Planning Application Ref: Y/42/19/DOC

Location: Yapton Metal Company, Burndell Road, Yapton, BN18 0HP

Description of works: Approval of details reserved by condition imposed under ref Y/53/16/PL relating to Condition Nos 3 - surface water drainage, 4 - maintenance & management of SuDs system, 5 - site set up and **7 - protective fencing/site monitoring**

Drawing Reference : J20438_Arb_TPP_A

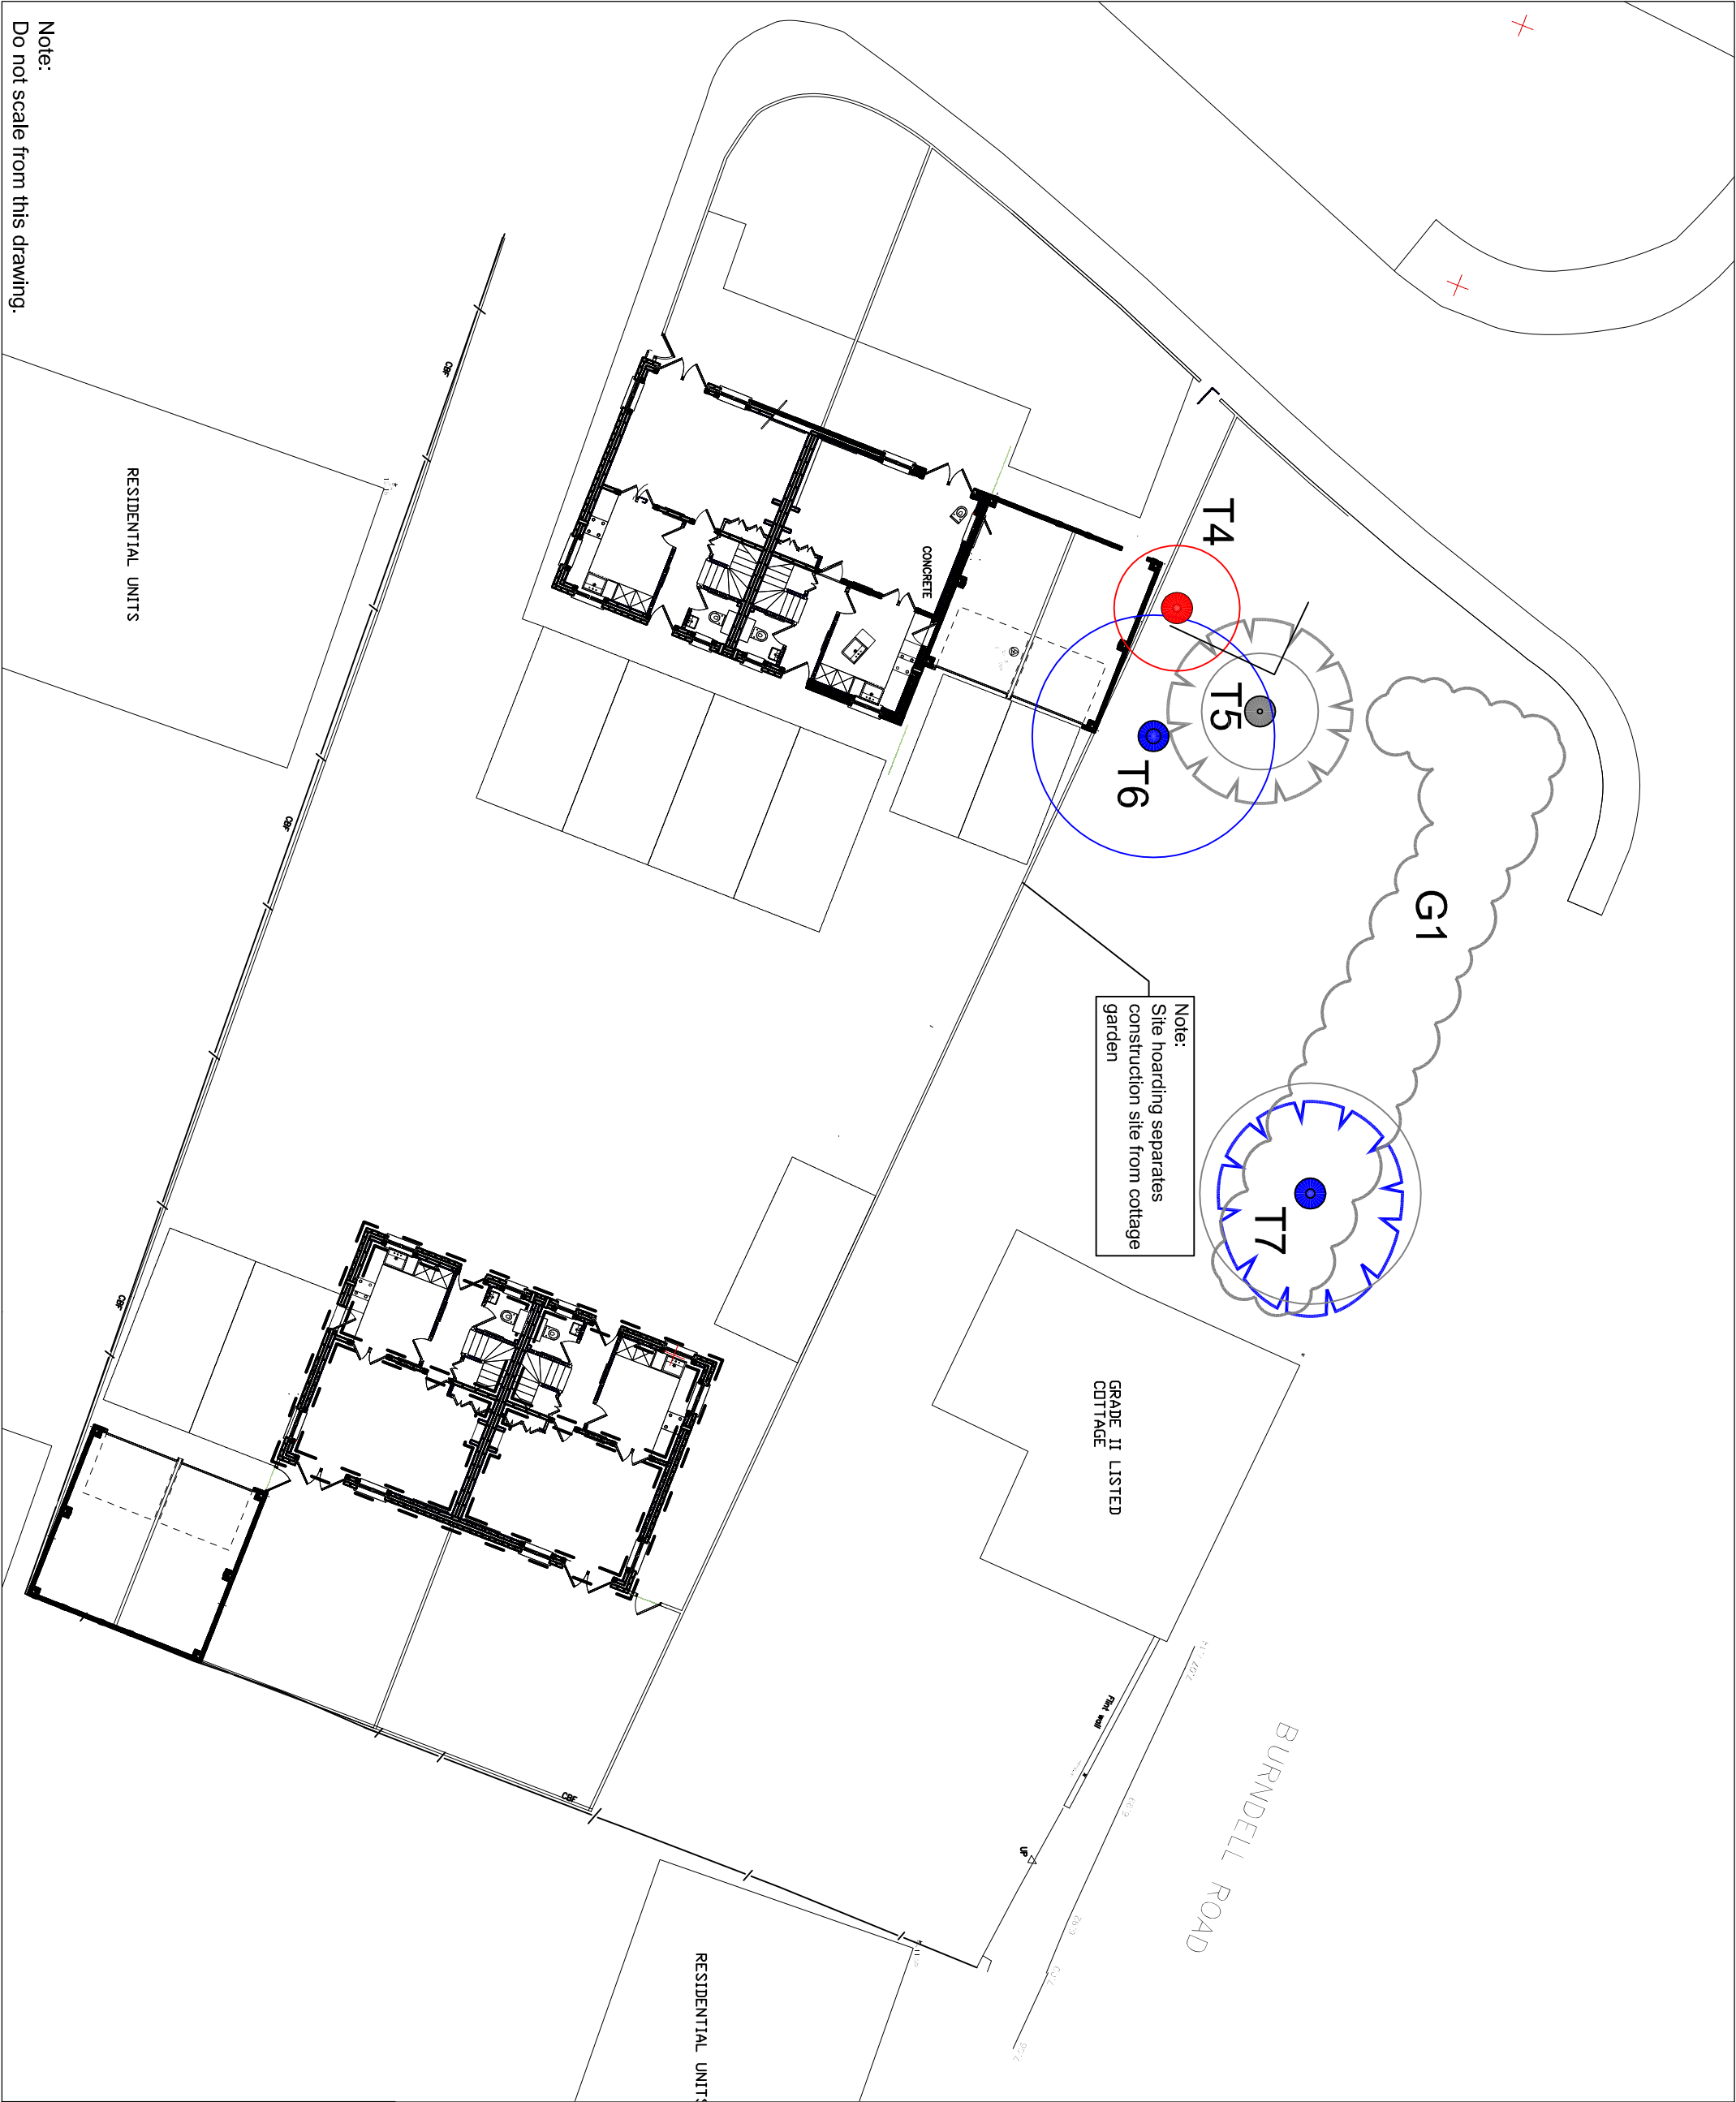
- The applicant has submitted a revised Tree Protection Plan, J20438_Arb_TPP_A, 24-07-19 in support of this application which differs greatly from that which forms part of the above condition.
- This revised plan (Rev A) illustrates a logic based on current reality on the ground in respect of layout and tree retention, although it assumes approval of application Y/61/19/PL (amended site layout).

- In any event, the construction on site is well under way with garage units to the north of Block A nearing completion, numerous tree removals having occurred (including T6) and as such no remaining requirement to either install protective fencing or maintain site hoarding.
- I am not aware of any pre-commencement site meeting having occurred, nor auditable trail of monitoring/supervision to confirm that the approved tree protection measures were in place at any time.

- The applicant has not yet been able to demonstrate any part of this condition has been complied with.
- Given the absence of any trees now overlapping the development, the construction phase of which is nearing completion - it is not possible to recommend any measures to recover a requirement for tree protection fencing/monitoring.
